**RE: Creekside PRD - Response to Technical Review #2
PA23-005**

Please refer to our responses below which address all review comments received from the City of Marysville dated 8/28 for planning, 9/25 for surface water, and 9/27 for traffic. Located at 7808 40th Street, 7811 & 7715 40th Street NE, APNs 29050200100200, 29050200100300, and 29050200100400. You will find the markup comments listed in the order that they were written followed by our response in *italics*.

HORIZON VIEW HOLDINGS, INC.  
**CREEKSIDE**  
PRELIMINARY ROAD, STORM DRAINAGE, AND GRADING PLAN

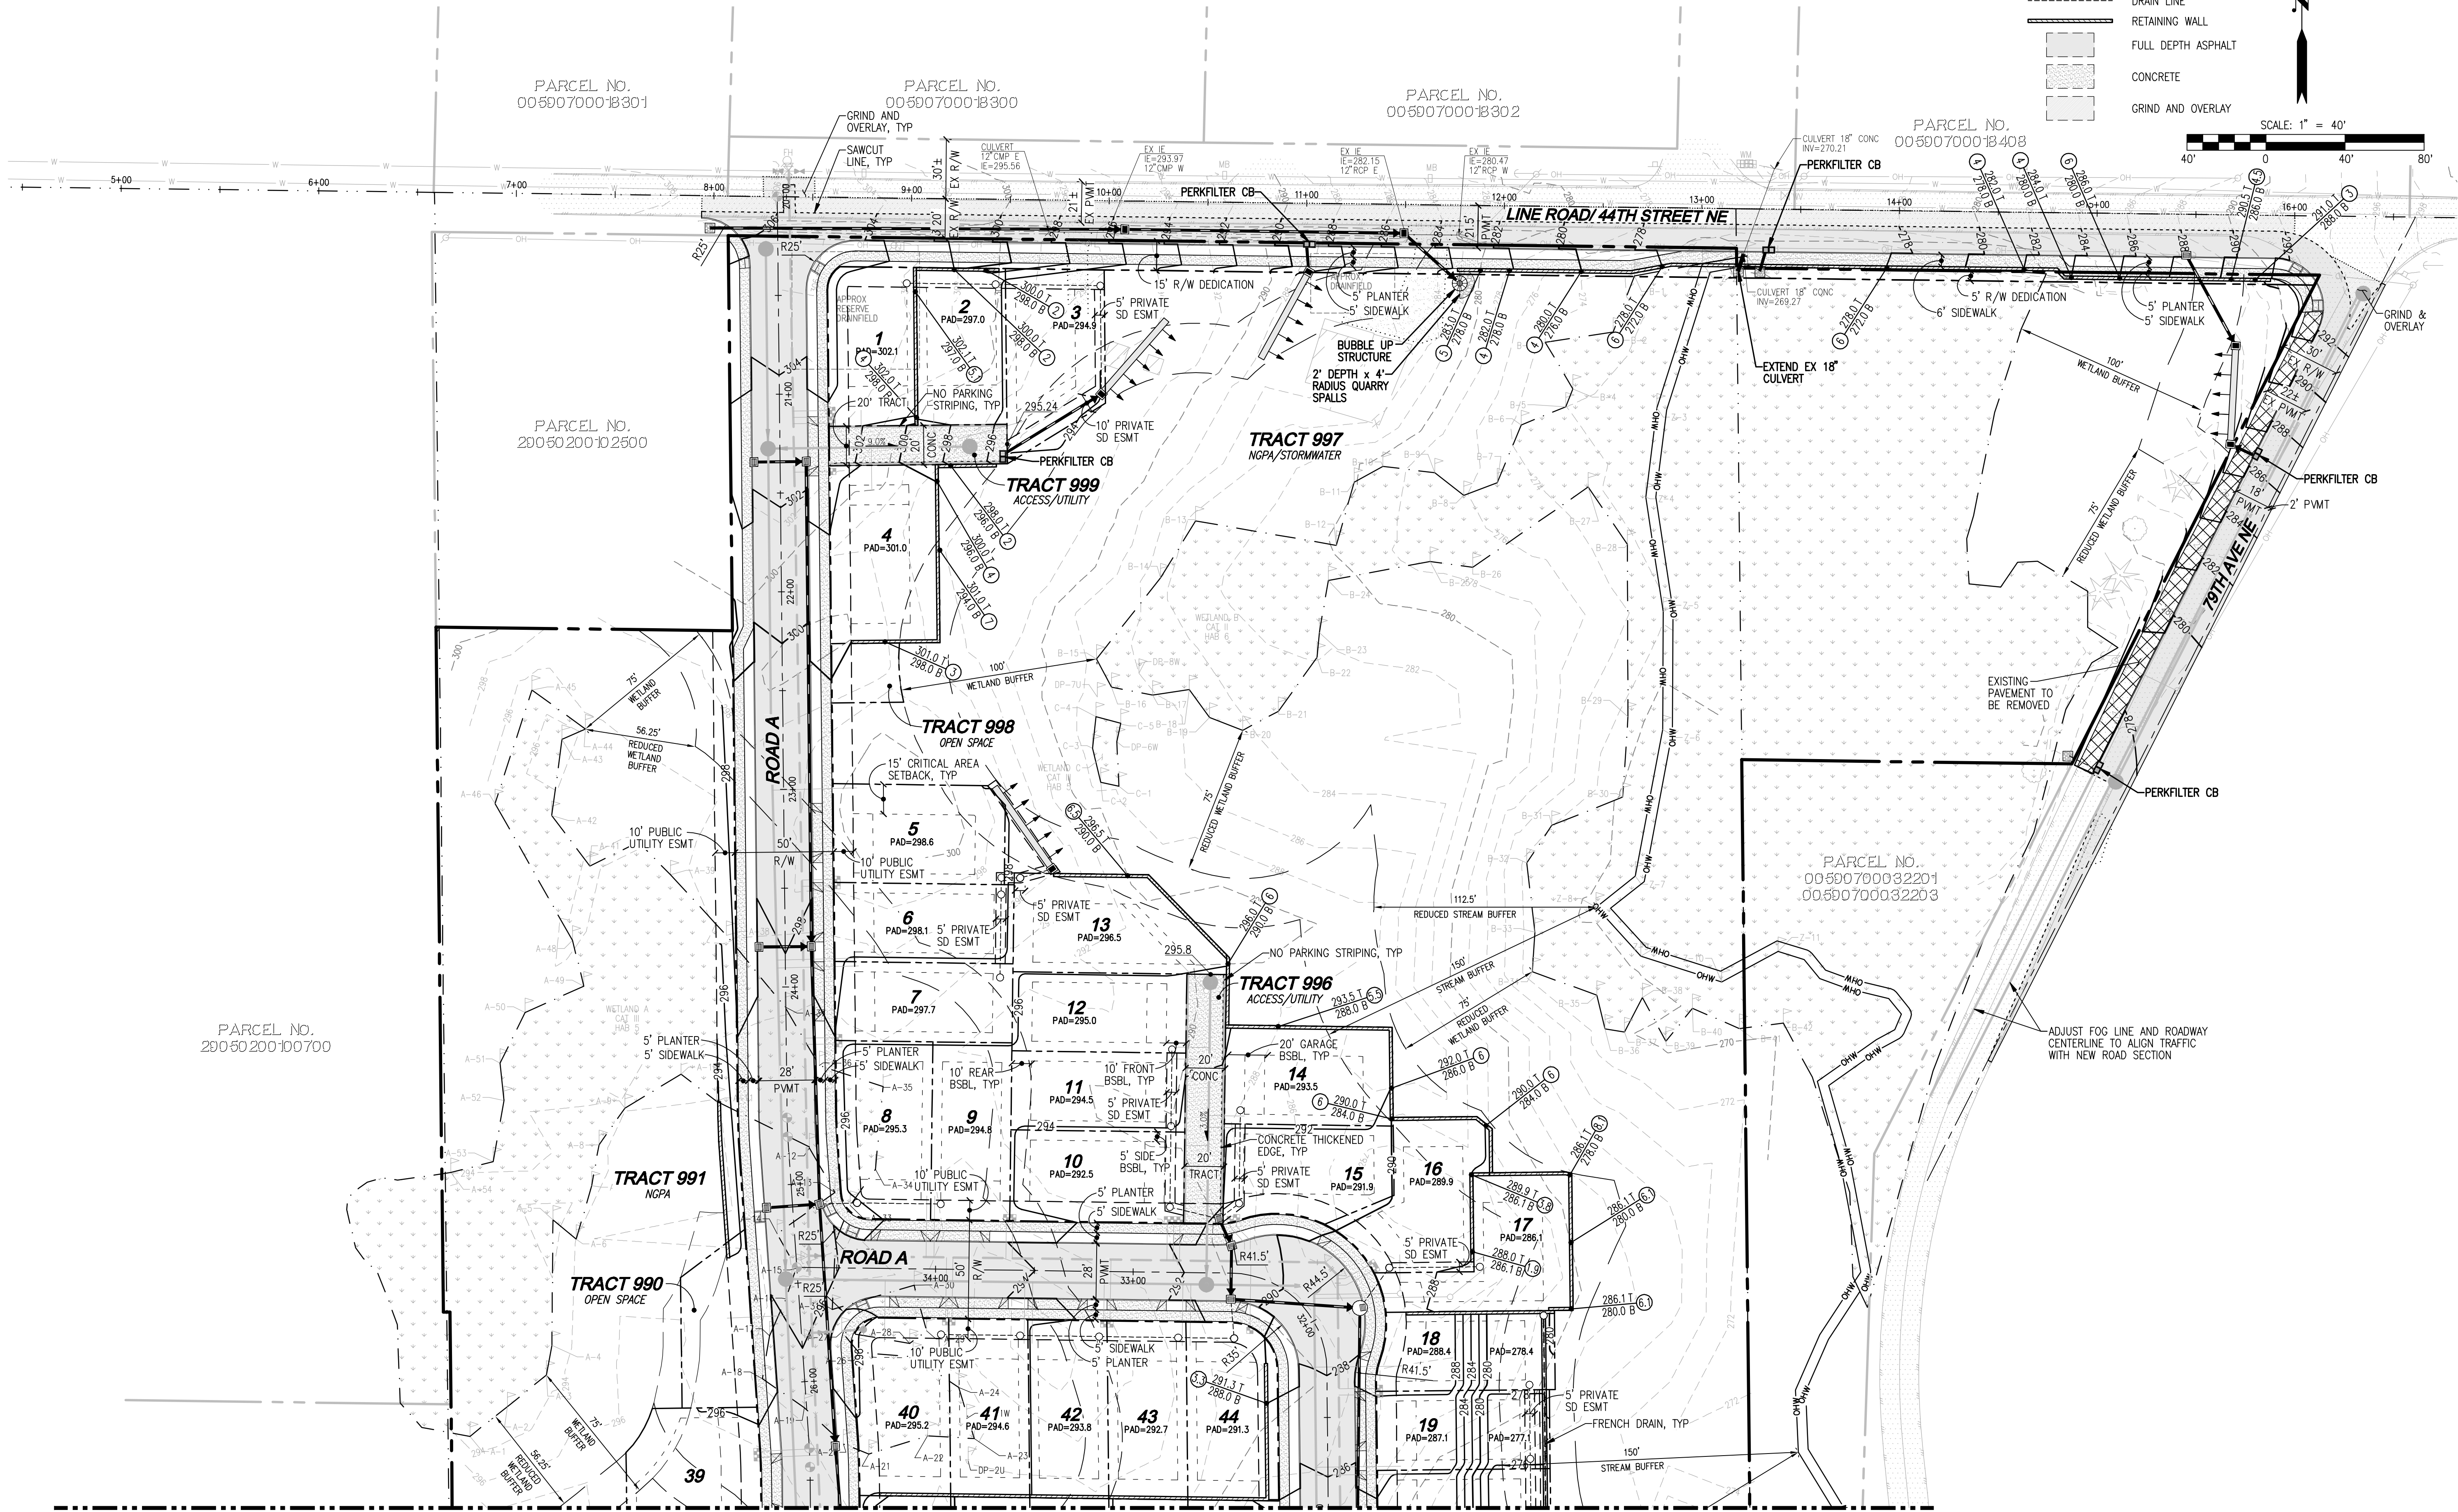
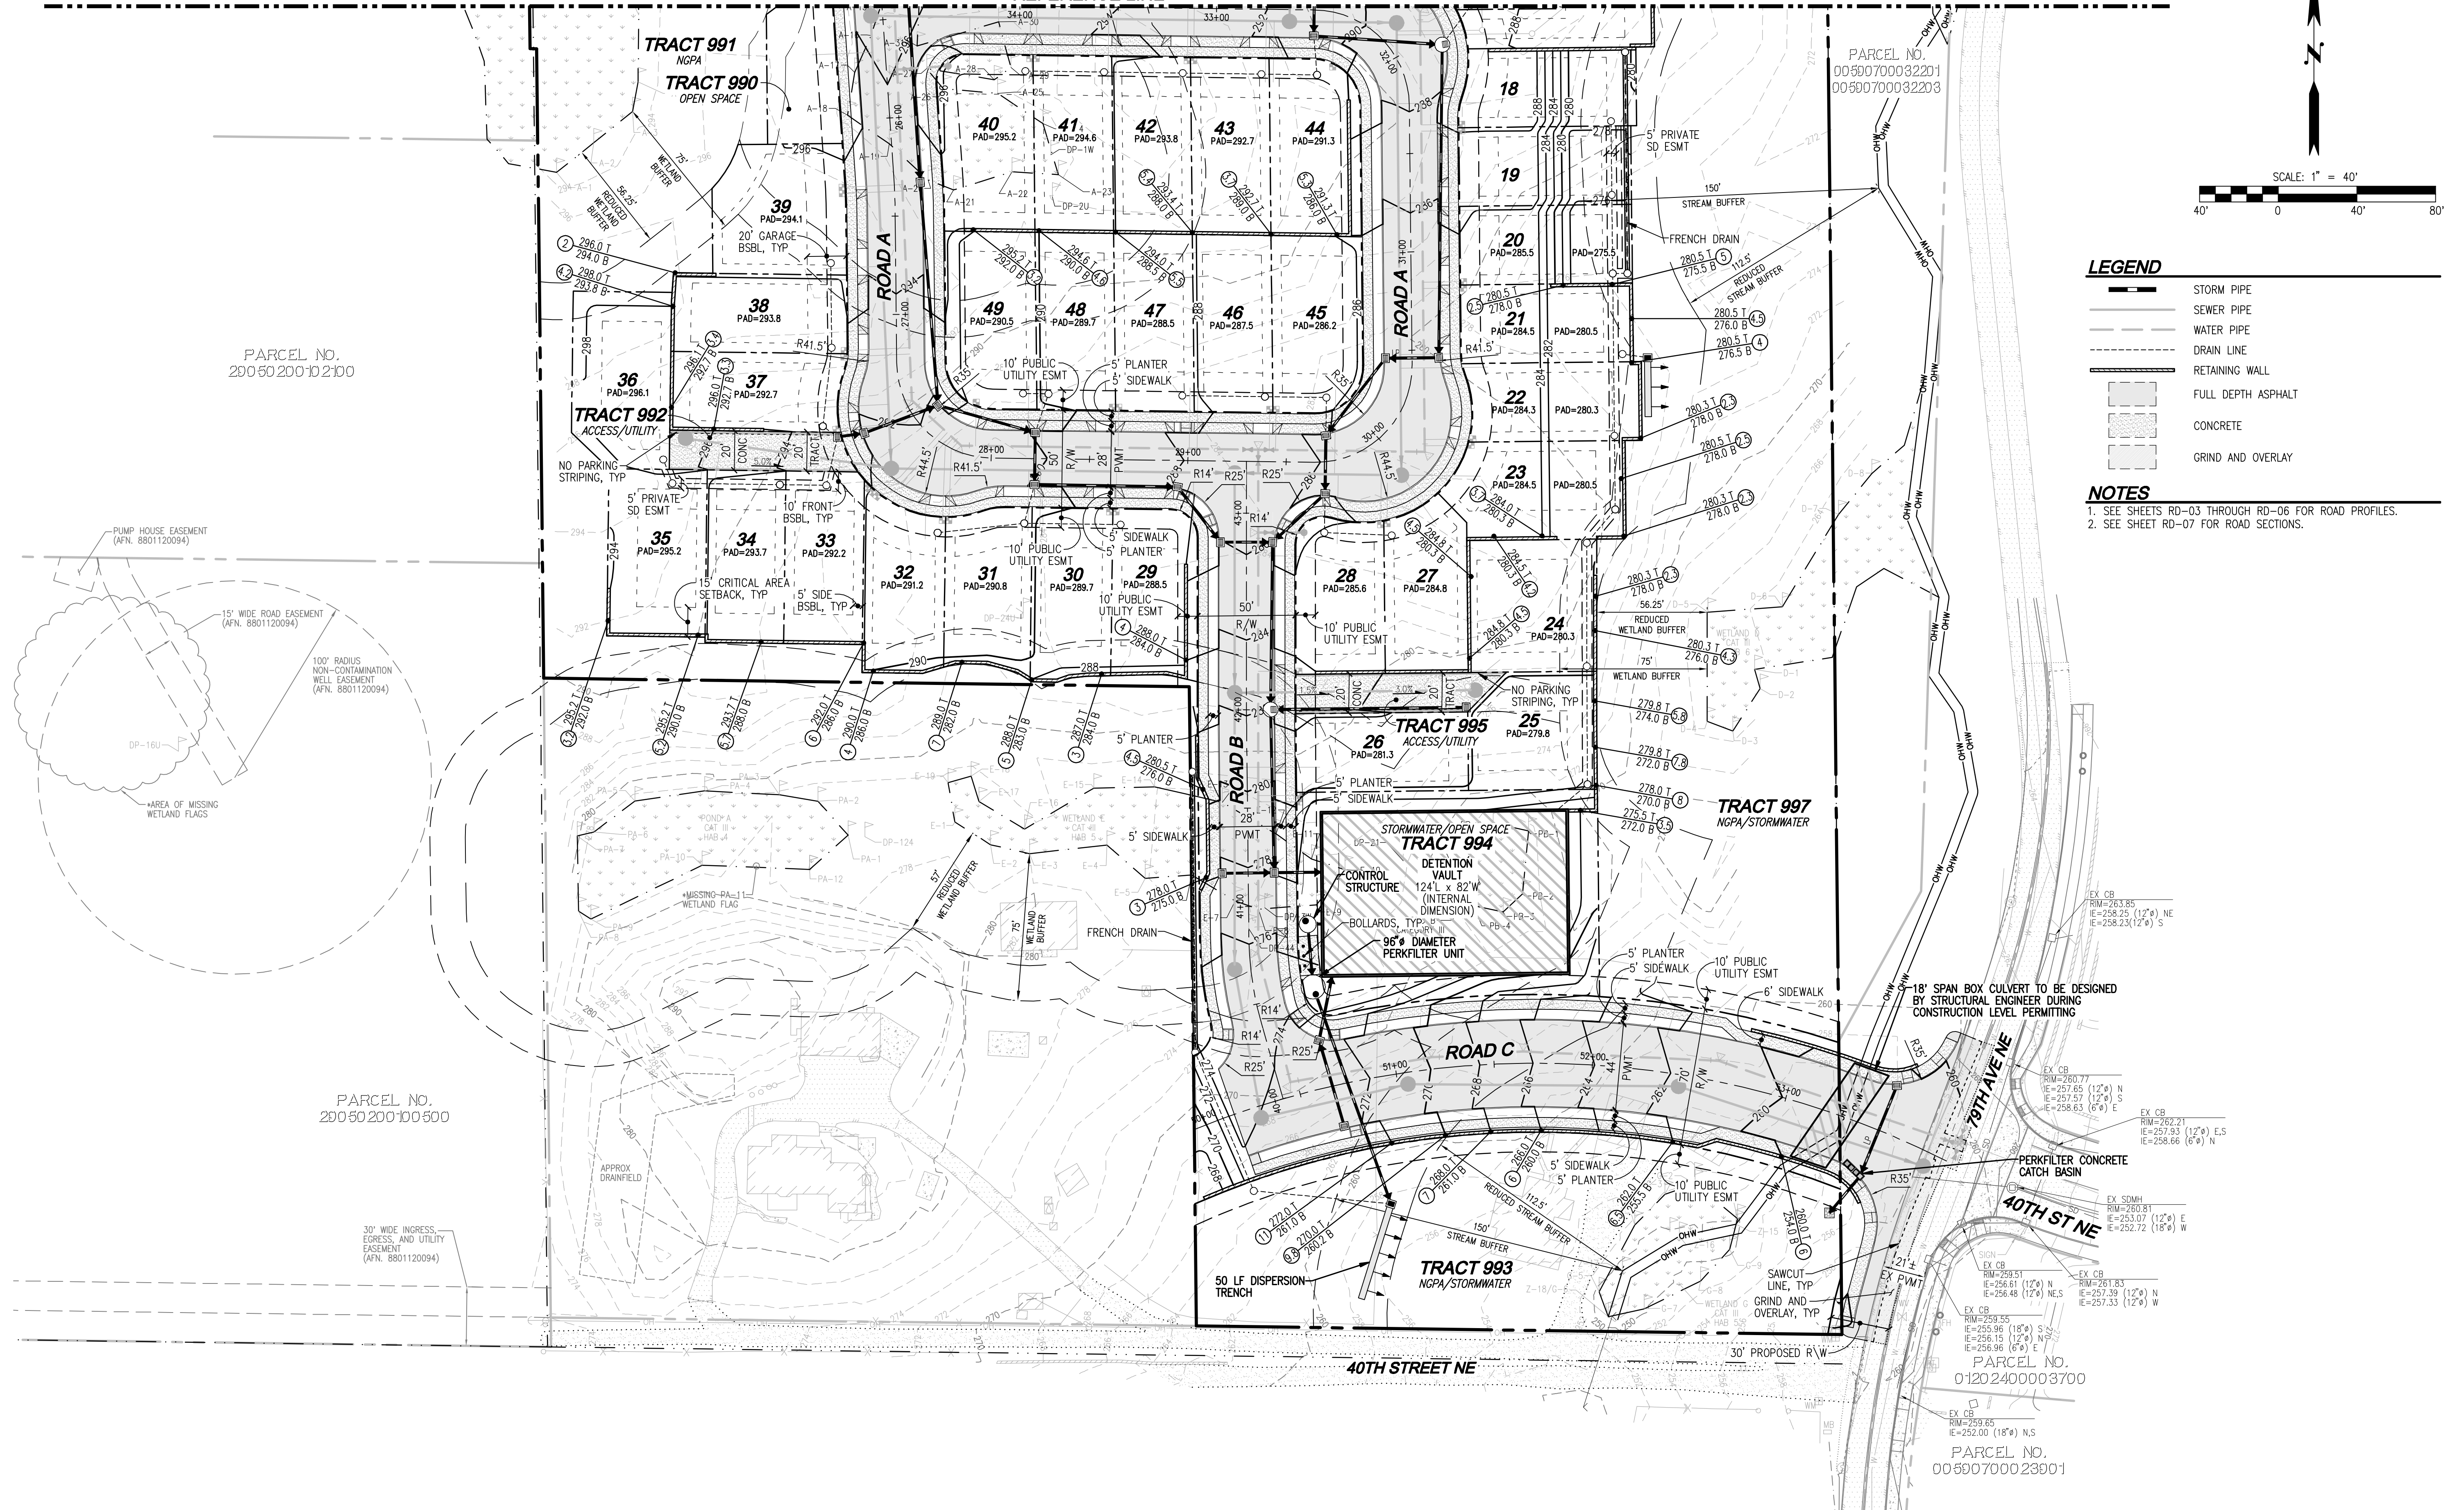
6. Pursuant to MMC 22D.050.030(4)(e), retaining walls taller than four feet shall be terraced so that no individual segment is taller than four feet. Walls between of lots 44 and 49, 27 and 24, along the southern boundary lots 29-35 , adjacent to 44th Street, and in scattered other locations, exceeding four feet will be required to meet the terracing requirements below. Lots directly abutting the wetland and *not visible* from adjacent lots or roadways are not required to meet these standards. Compliance will be verified during civil construction plan review.

14. Undergrounding of existing overhead utilities along all public roadway frontages shall be required.

Response: All referenced retaining walls have been revised to 4' maximum. See sheet RD-02 for the updated wall and lot grading design. Specific retaining wall designs will be provided as part of the future grading permit submittal package.

Response: Note has been added to sheets RD-01 and RD-02 stating "all existing utilities along 44th St NE and 9th Ave NE frontages shall be undergrounded."
